**From:** Denise Preisser <dpreisse@maine.rr.com>  
**To:** Jean Fraser <JF@portlandmaine.gov>  
**Date:** 2/6/2016 8:36 PM  
**Subject:** Re: 31 Fore Street

Hello Jean,  
Thank you for keeping me up to date on the plans of 31 Fore Street.

A2

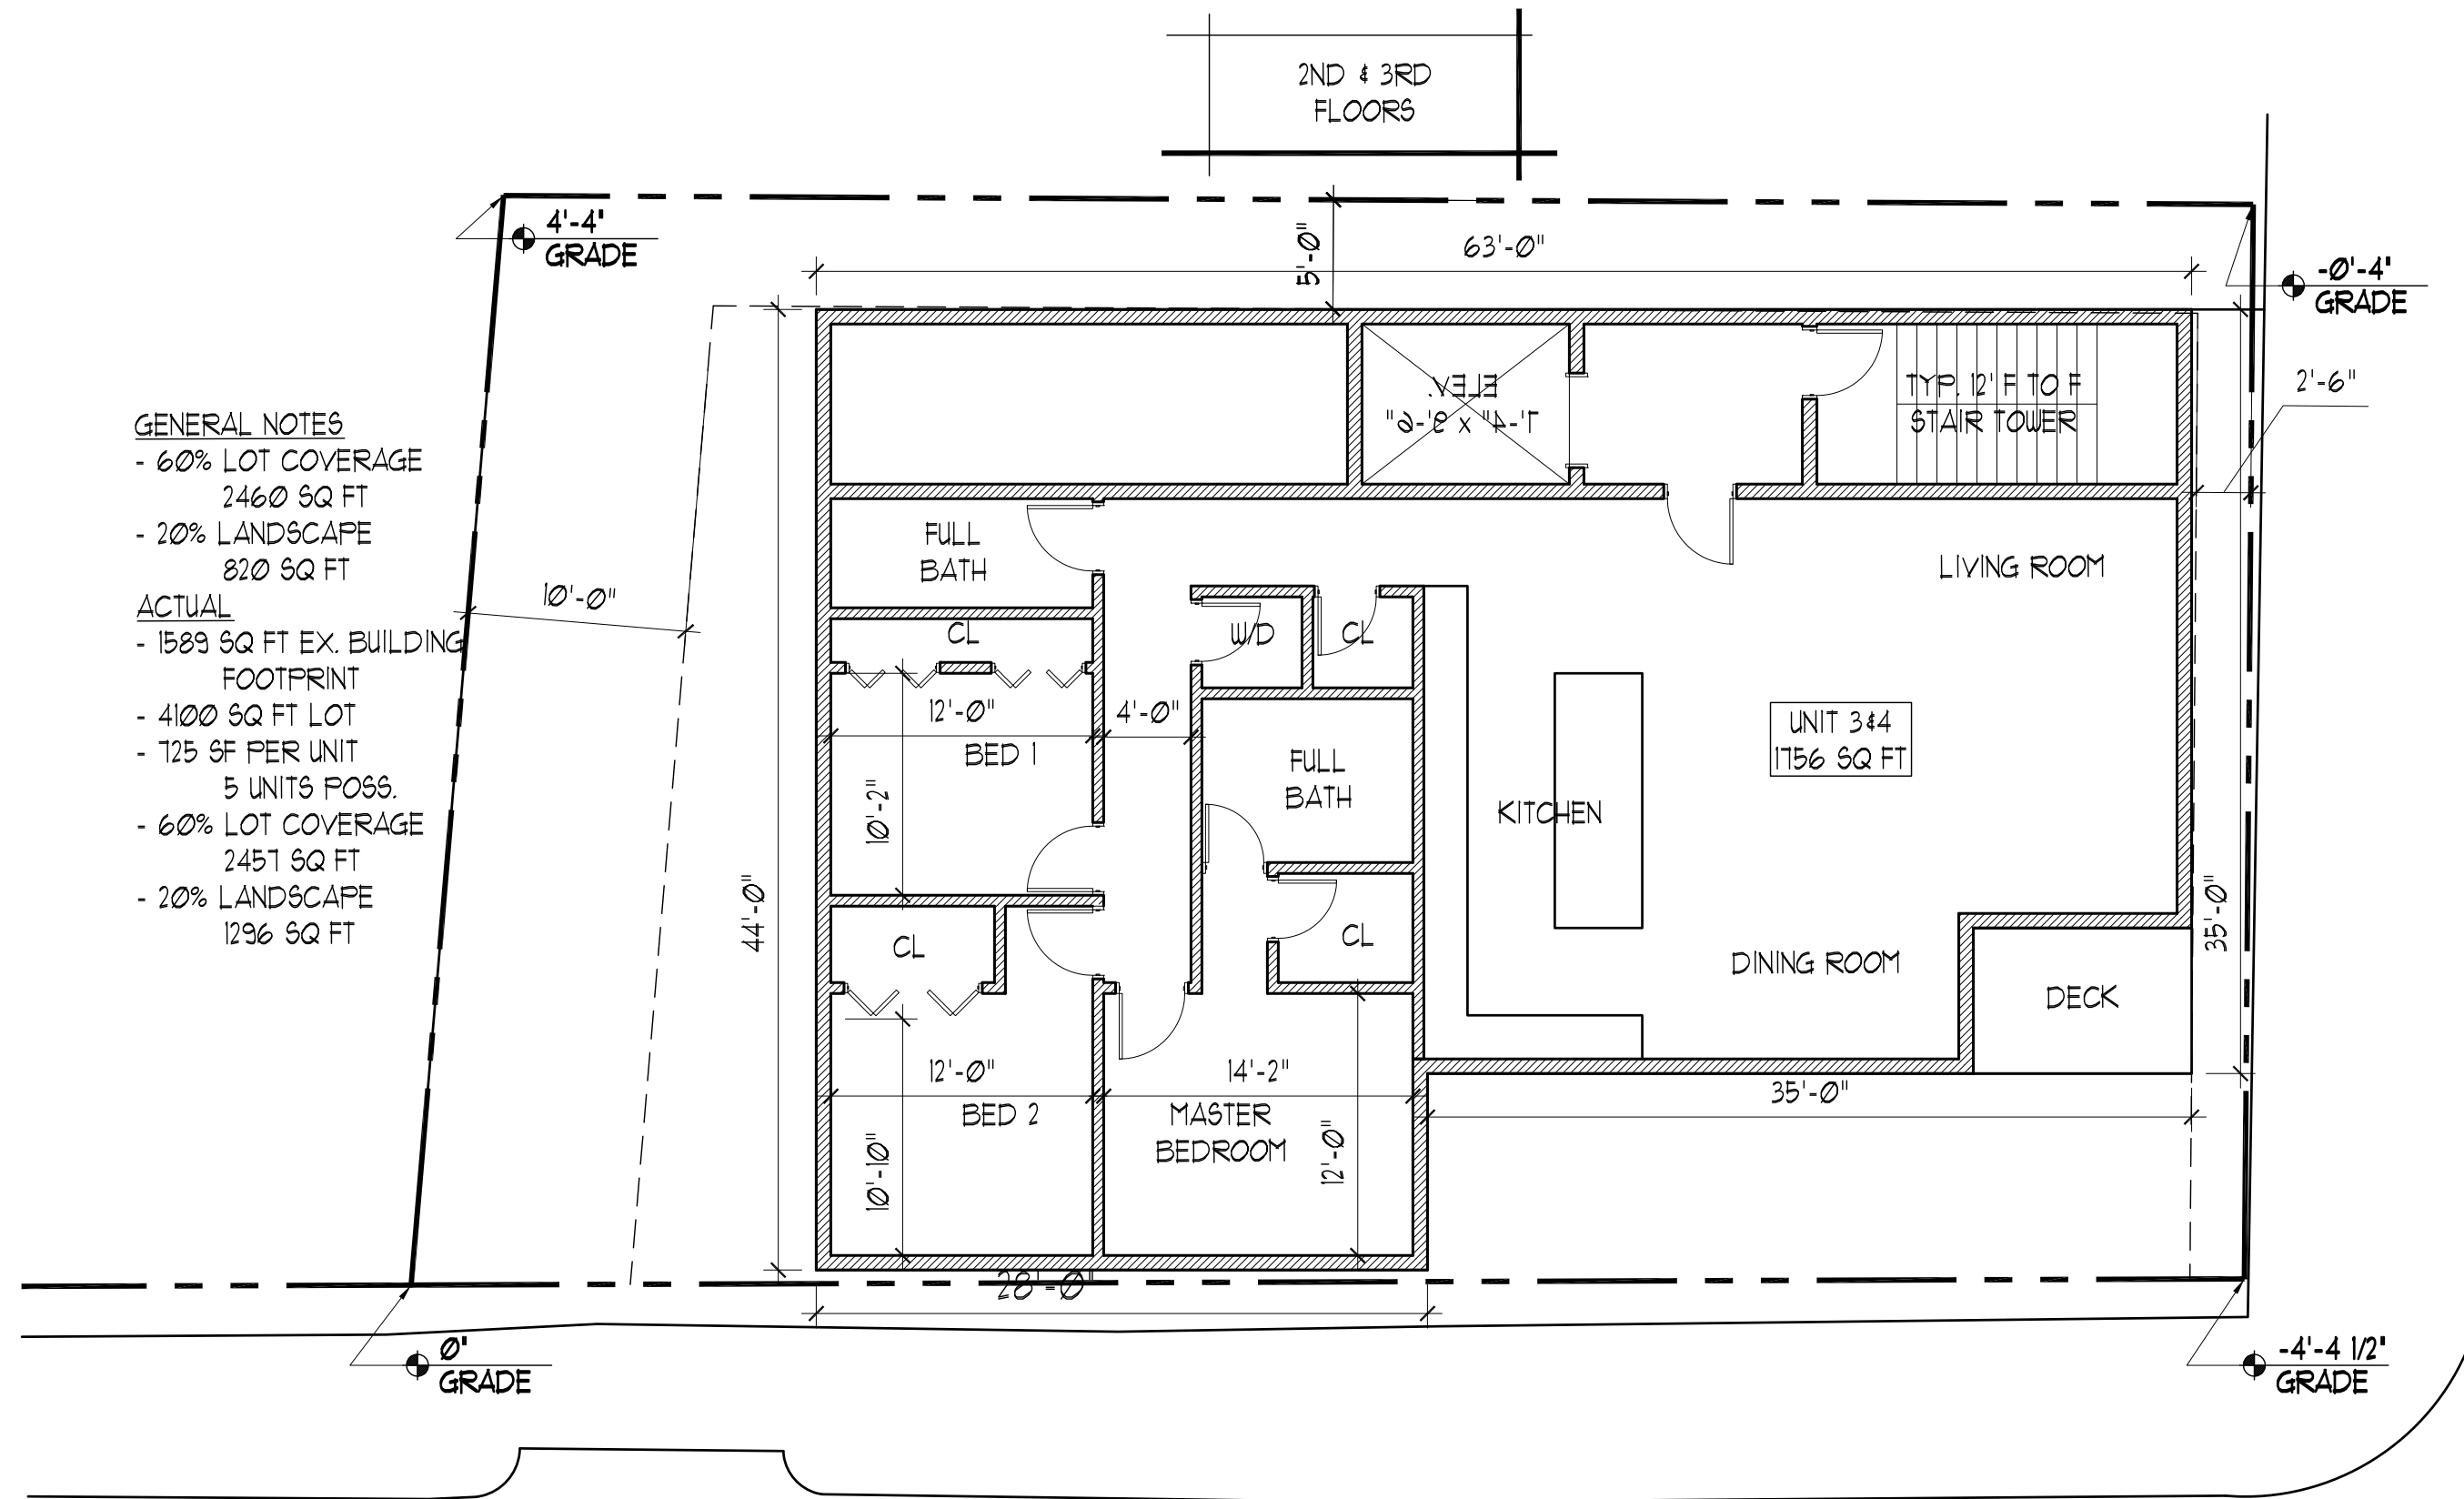
- The limited number of windows on the side of the building abutting the 25 Fore Street condo and garden pathway is a real plus. The buildings are so close and this new design provides privacy for both buildings. As I interpret the plans the windows on this side will be only be for stairs and landings for each floor.

- The visitor/delivery entrance abutting 25 Fore Street property line does not seem to be an effective screening for privacy for 25 Fore decks and garden area. At this time our space is gated for security and privacy and this plan looks like anyone could walk up this side entrance and have access to our property. I want to make sure the developer makes provisions to compliment both properties, but also maintain the privacy and security for 25 Fore property that now exists. My first choice would be not to have an entrance on this side however, if that can not be addressed, I suggest fencing be added to define secure our property lines (like we currently have) and/or vegetation added that enhances the 5 foot space to be added the length of the building with the new footprint of this building.

- The curb appeal of the ground front and parking side areas needs special attention. This is a massive amount of siding that is a great wall for graffiti. Vegetation would enhance this since so much green space is being lost with this new building filling in grass area to the sidewalk.
